DECISION DELEGATED TO DEVELOPMENT MANAGER

Application No: H05-0434-20 **Applicant:** Mr P Vijayaratnam
Proposal: Replace existing porch, new dormer extension and alterations
Location: 24 Fleet Road Fleet Spalding
Terminal Date: 27th August 2020

Drawing Title:
PROPOSED GROUND FLOOR PLAN

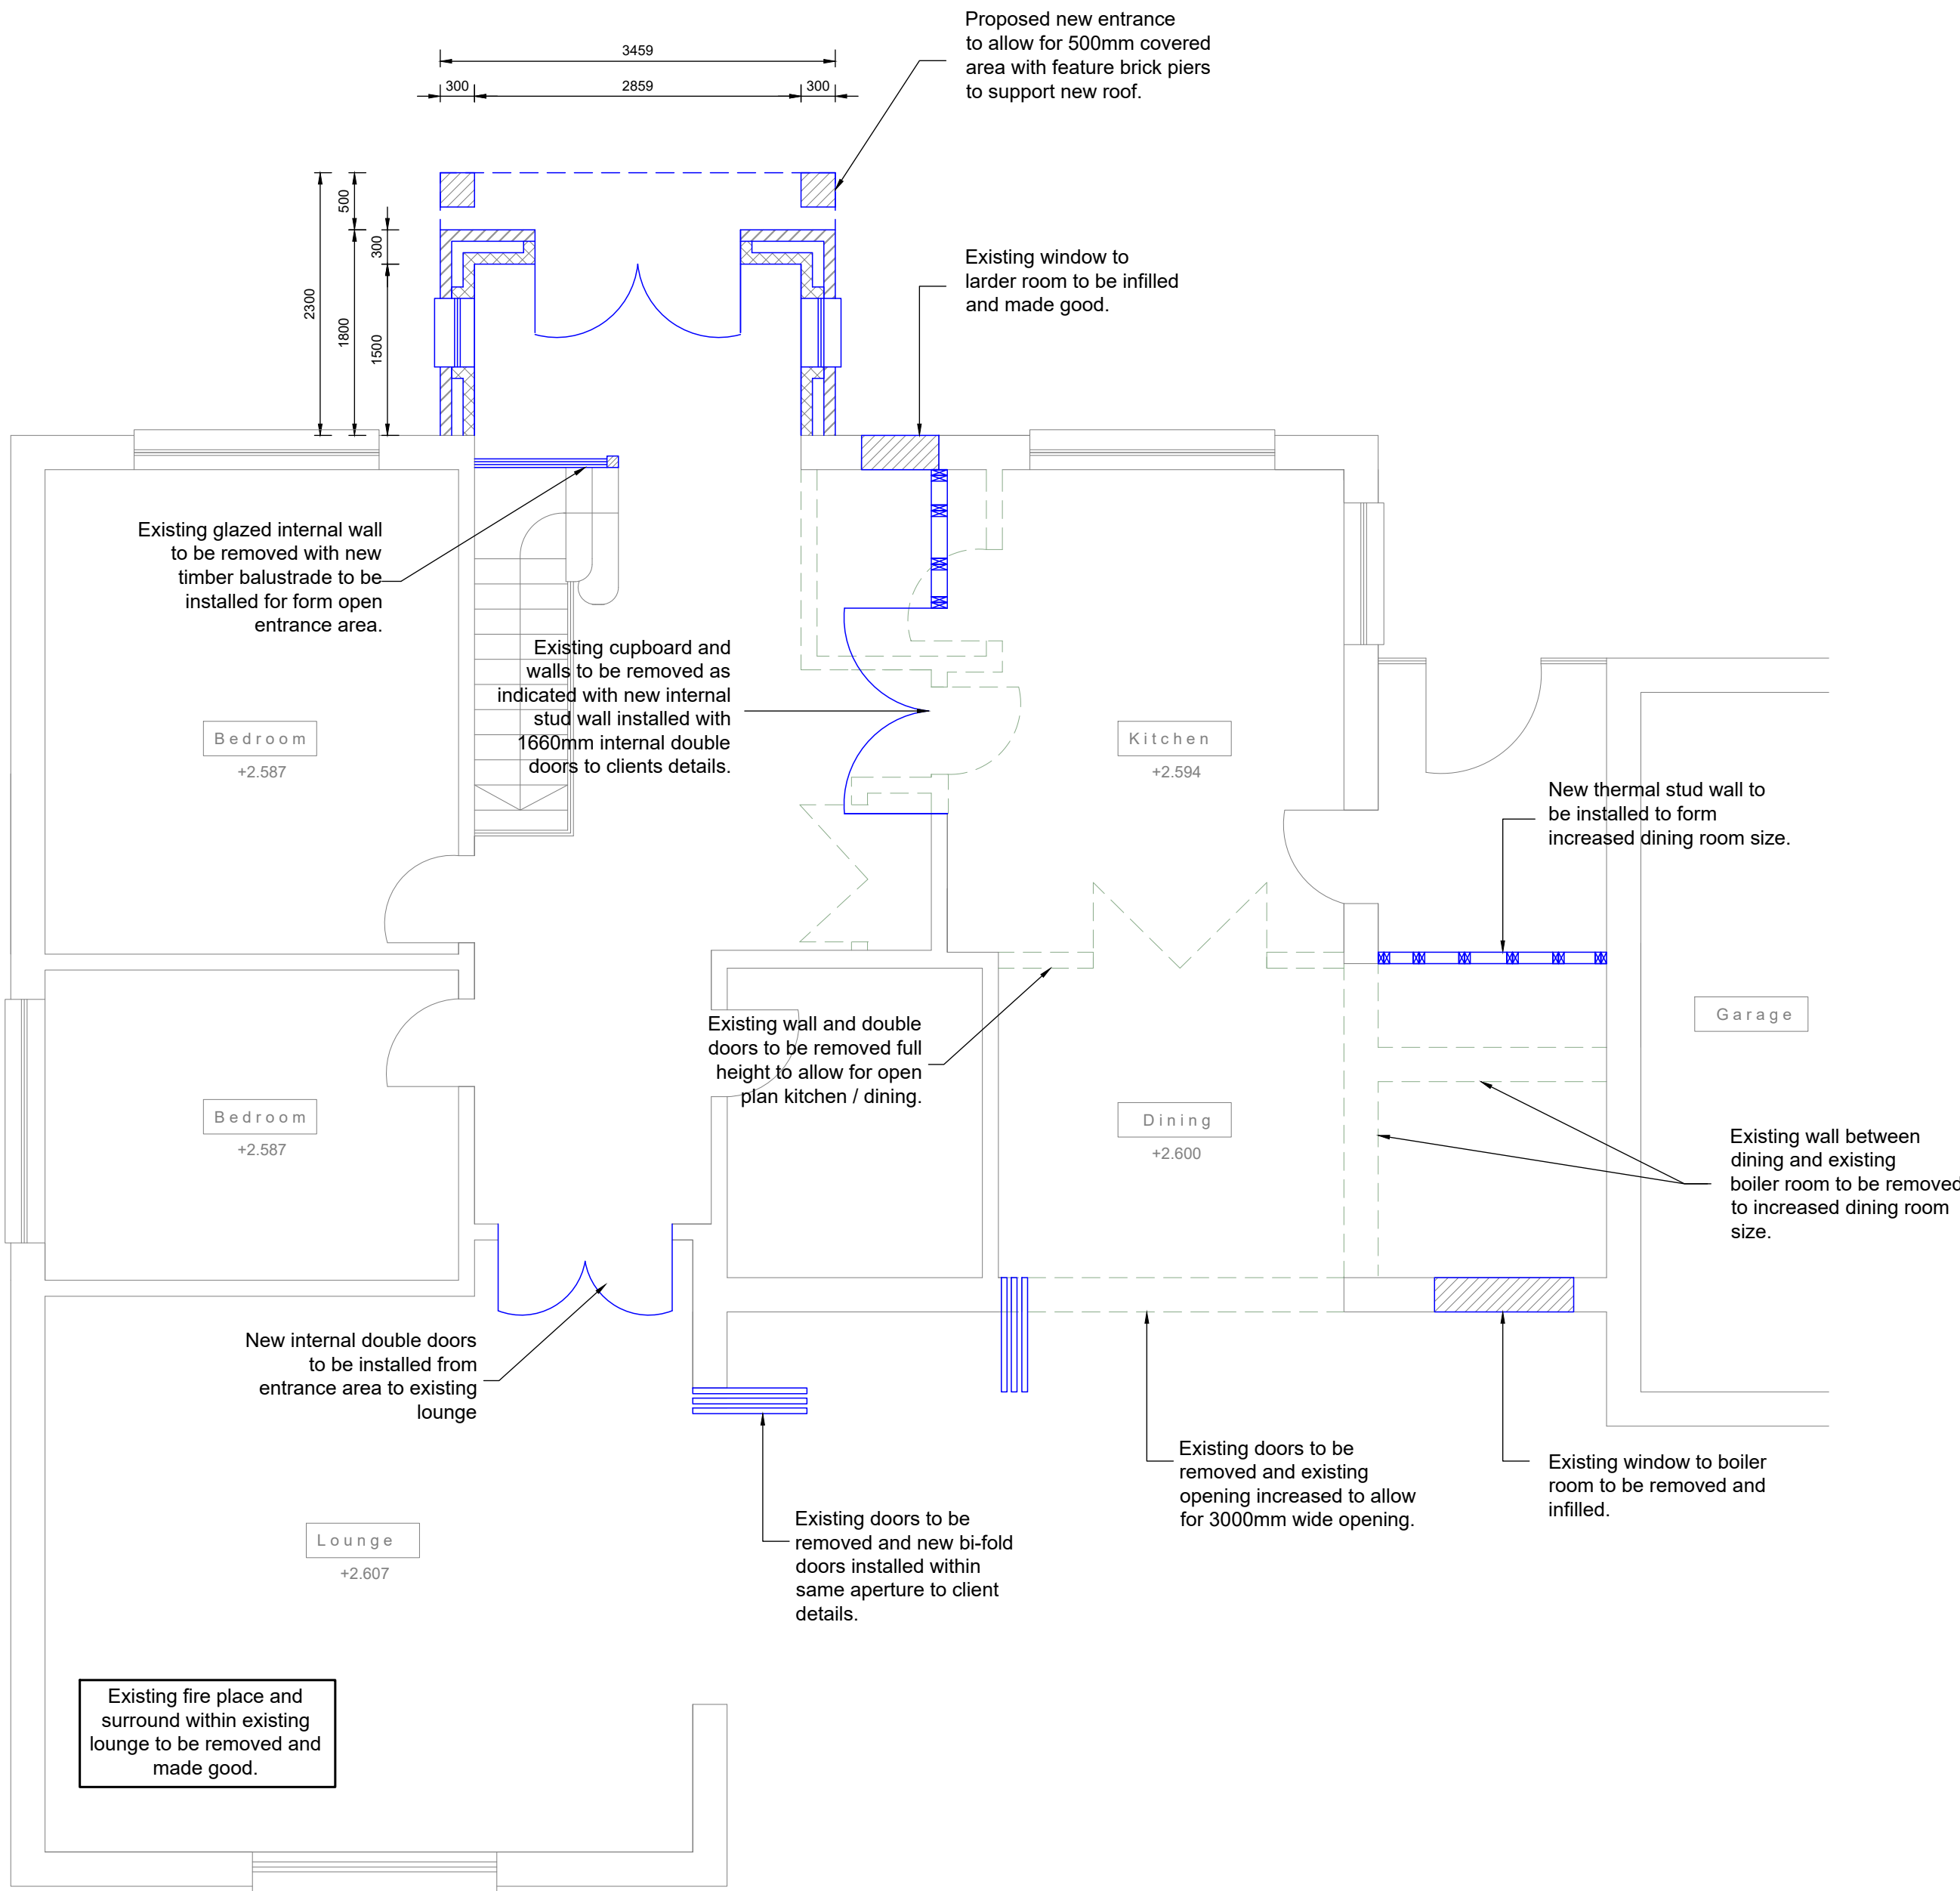
The existing front conservatory will be replaced for a flat roof brick porch. The footprint and height of the proposed porch will not differ dramatically from the structure to replace. The dimensions of additional dormer window will be tantamount to the other two existing dormer openings. Therefore, the external elements of the proposed development will appear subservient to the host property in terms of scale, mass and bulk.

The porch roof will be sustained by two brick piers. The dormer window will have a hip gable pitched roof as the existing roof openings. The window layout will replicate those existing. The external materials of both porch and dormer will match those existing in the property, thereby the visual amenity will not result undermined.

Drawing Title:
PROPOSED FIRST FLOOR PLAN

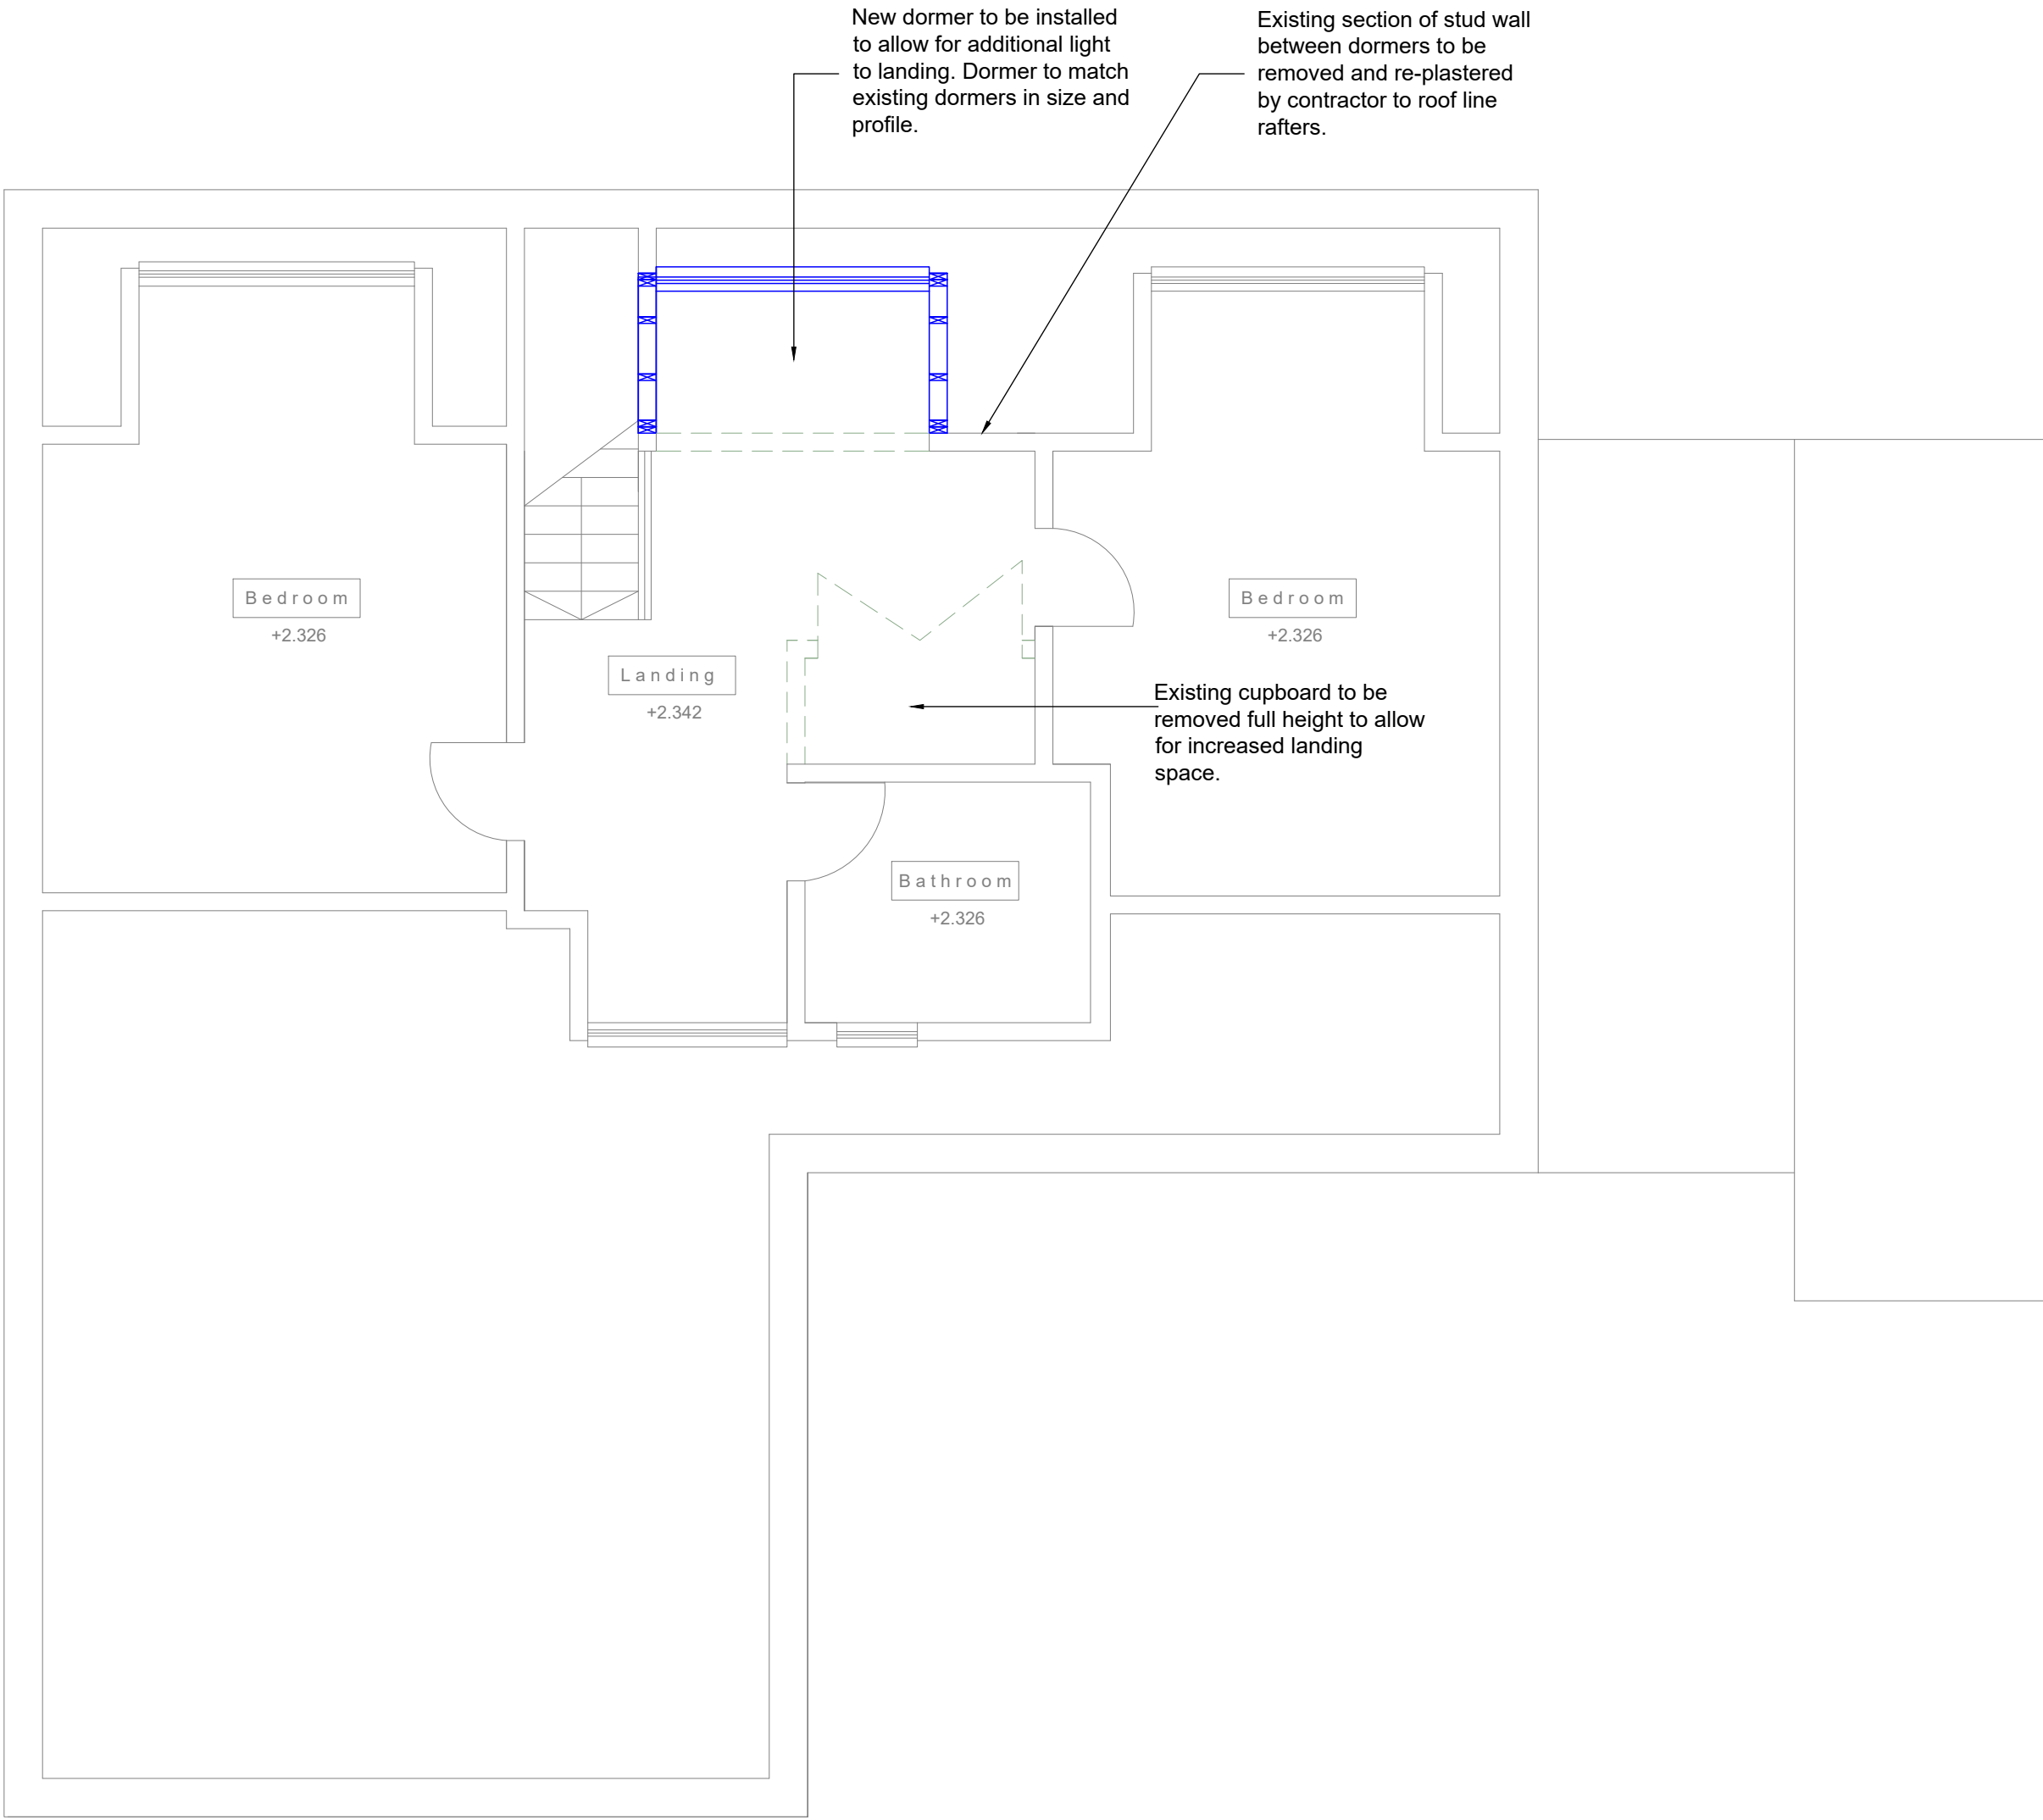
The proposed external works will not undermine the amenity standards of residents nearby. The dormer window will not directly overlook other openings or adjacent plots. The porch is acceptably designed to the extent that it will not reduce the daylight through adjoining openings on the first elevation of the dwelling.
